**Atlas-Campaspe Mineral Sands Project**  
**Responses to the Department of the Environment Review Comments (dated 30 August 2013)**

**1.1.1 Commonwealth Government (30 August 2013) states:**

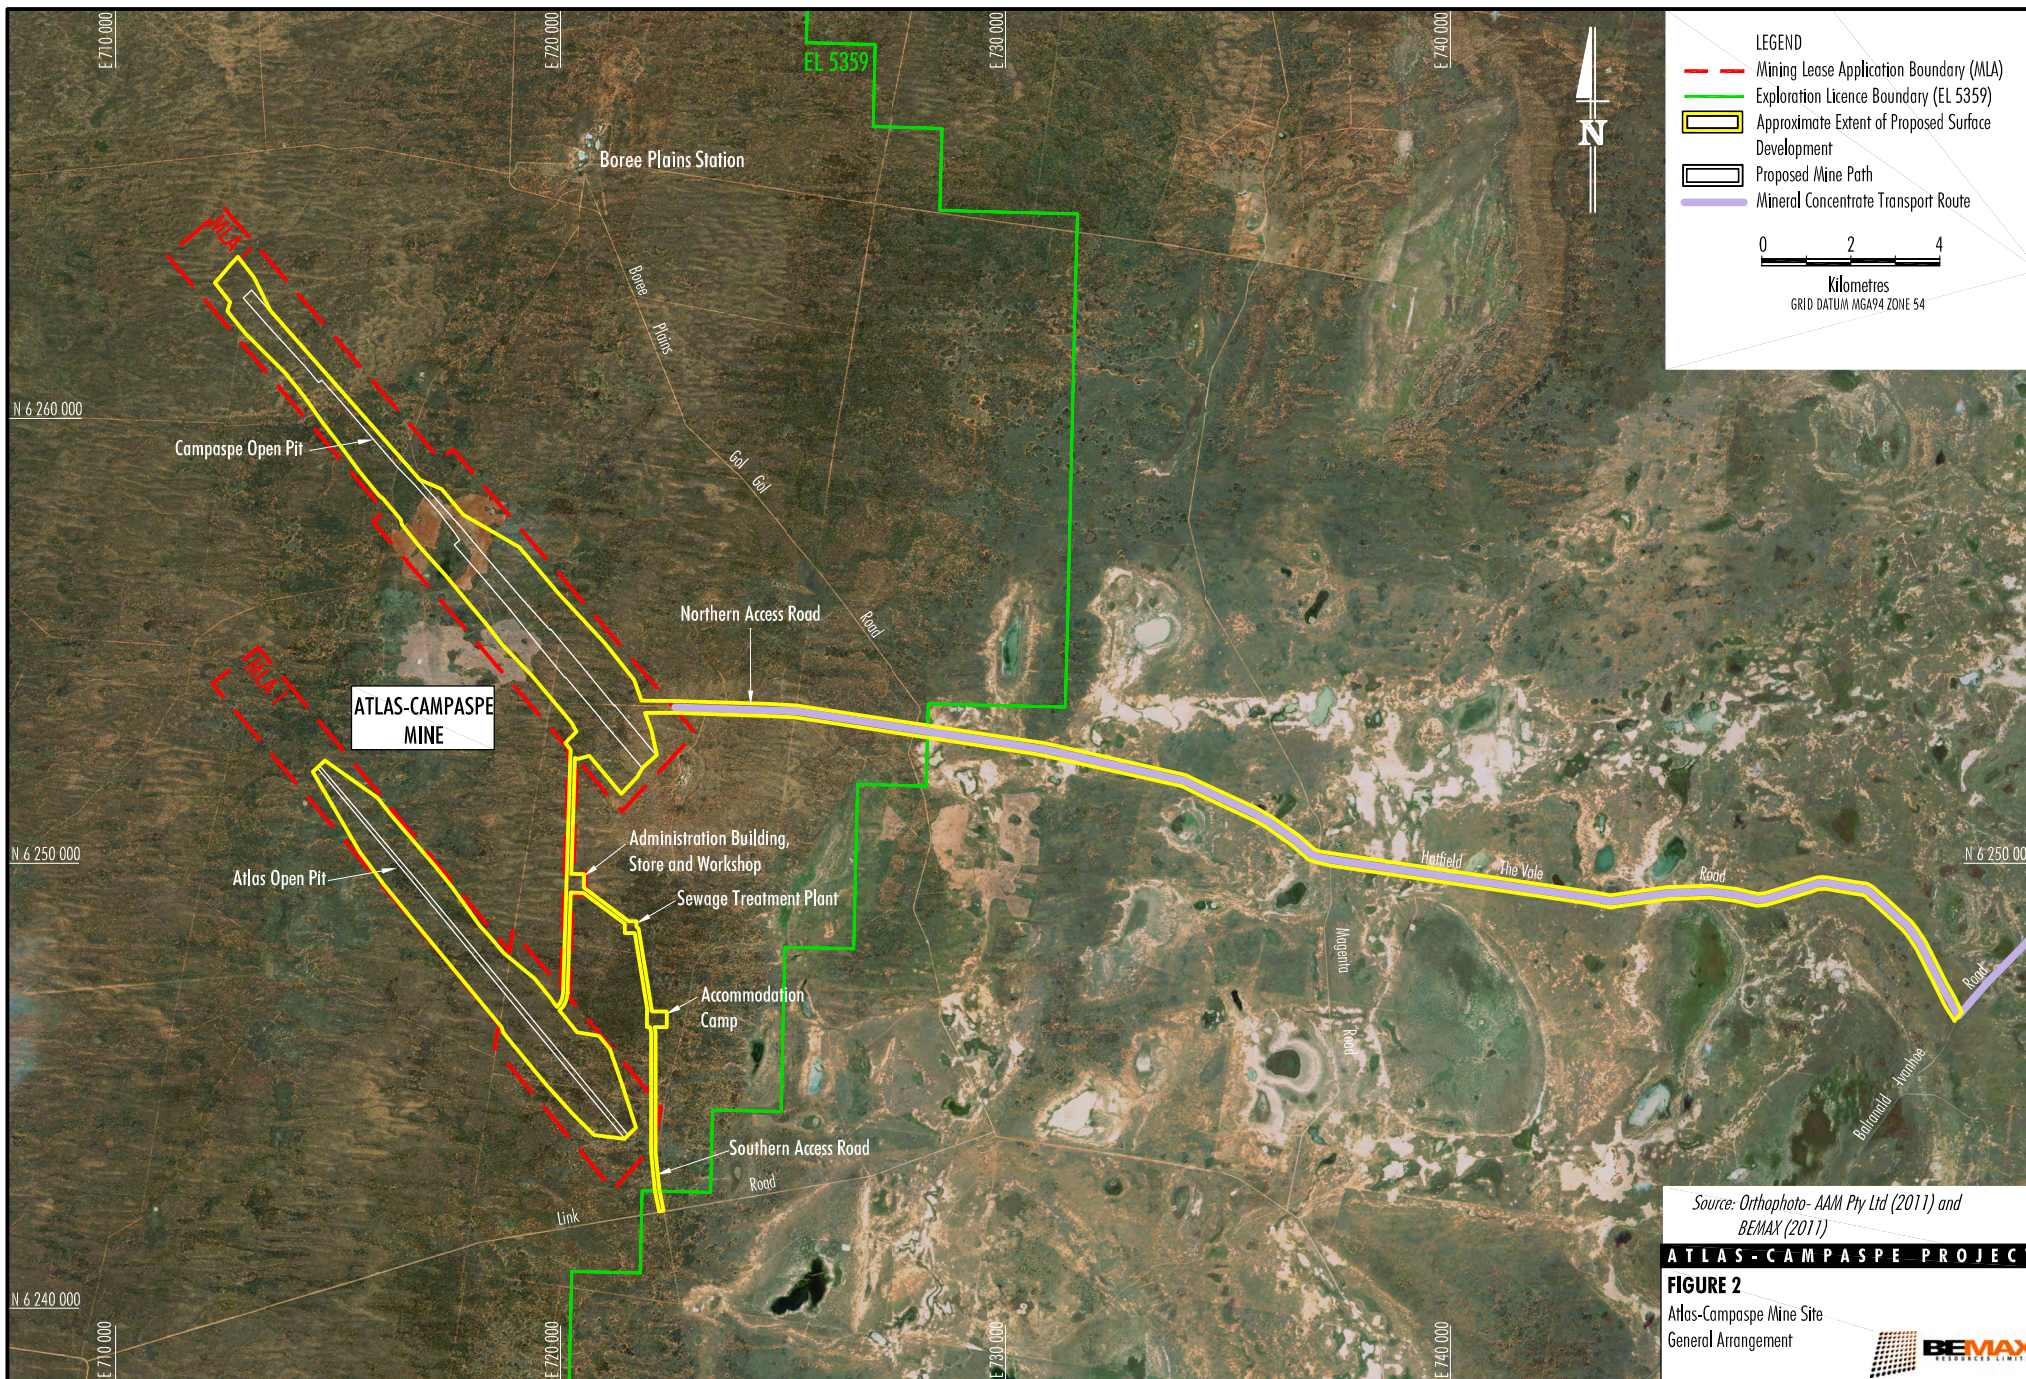
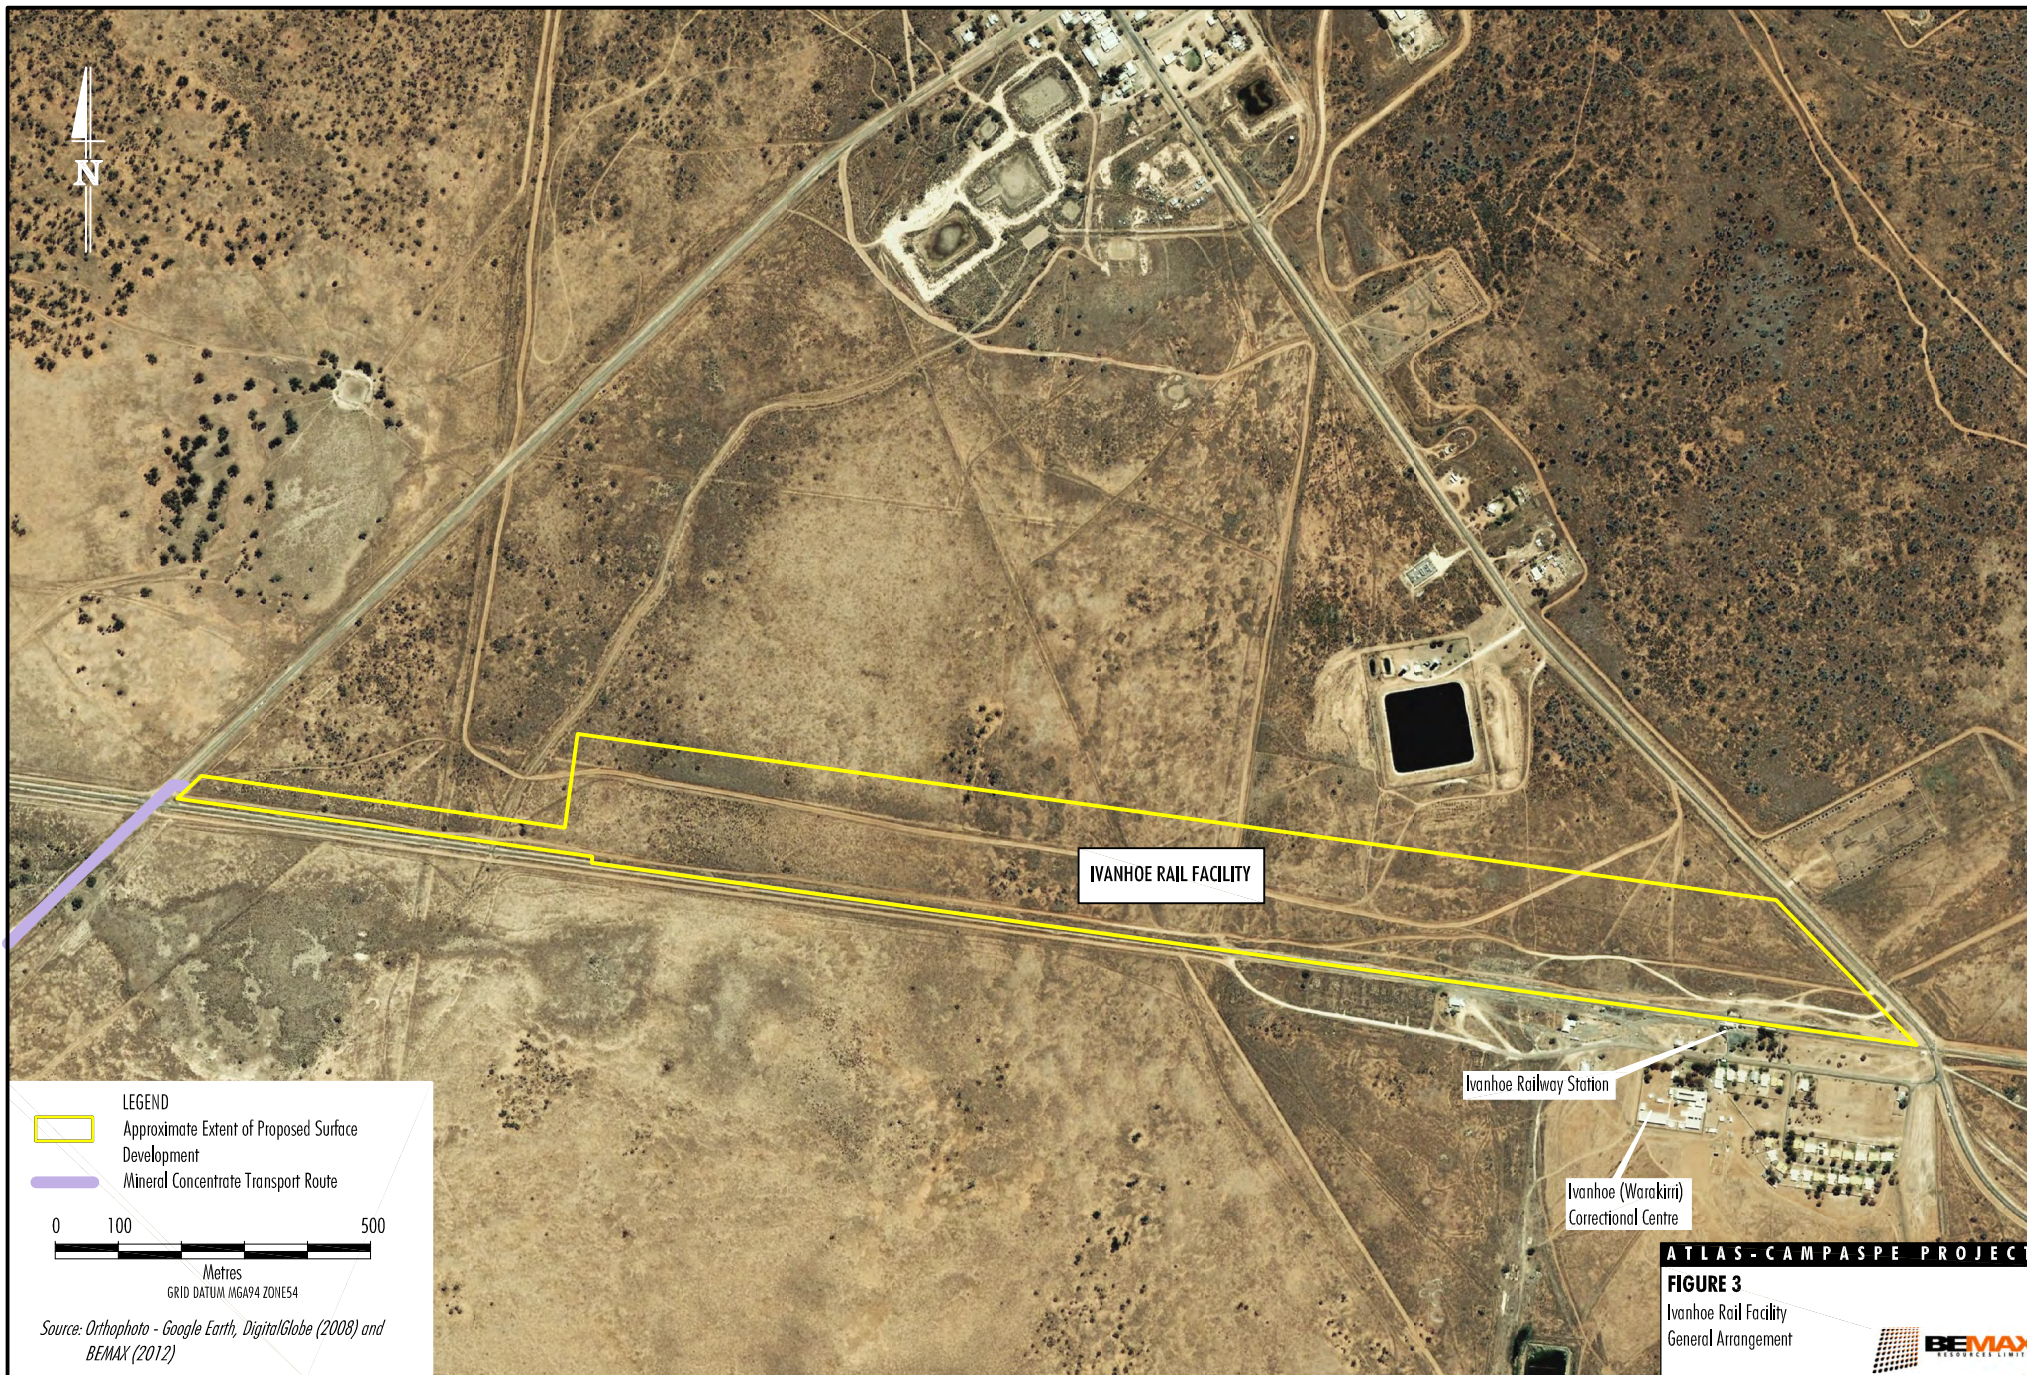
***The area (in hectares) of each component of the action, including but not limited to, the proposed infrastructure at the mine site (identified in Figures 2-4 and 2-5 of the EIS) is still outstanding.***

As described in the EIS, the Project would have a disturbance footprint of 4,463 hectares (ha), which includes approximately 4,158 ha of native vegetation and 305 ha of previously cleared land. Table 2 shows the approximate area to be disturbed by the Atlas-Campaspe Mine footprints, proposed Mineral Concentrate Transport Route and Ivanhoe Rail Facility.

<b>Project Component</b>	<b>Approximate Area (ha) (as shown on Figures 2-3 to 2-9 of the EIS)</b>
Atlas- Campaspe Mine Footprints:	
• Mine Path	880
• Fixed Infrastructure	755
• Accommodation Camp	40
• Other (stockpiles, overburden emplacements, roads, etc).	2,650
Proposed Mineral Concentrate Transport Route widening	98
Ivanhoe Rail Facility (including access road)	40
<b>Total</b>	<b>4,463*</b>
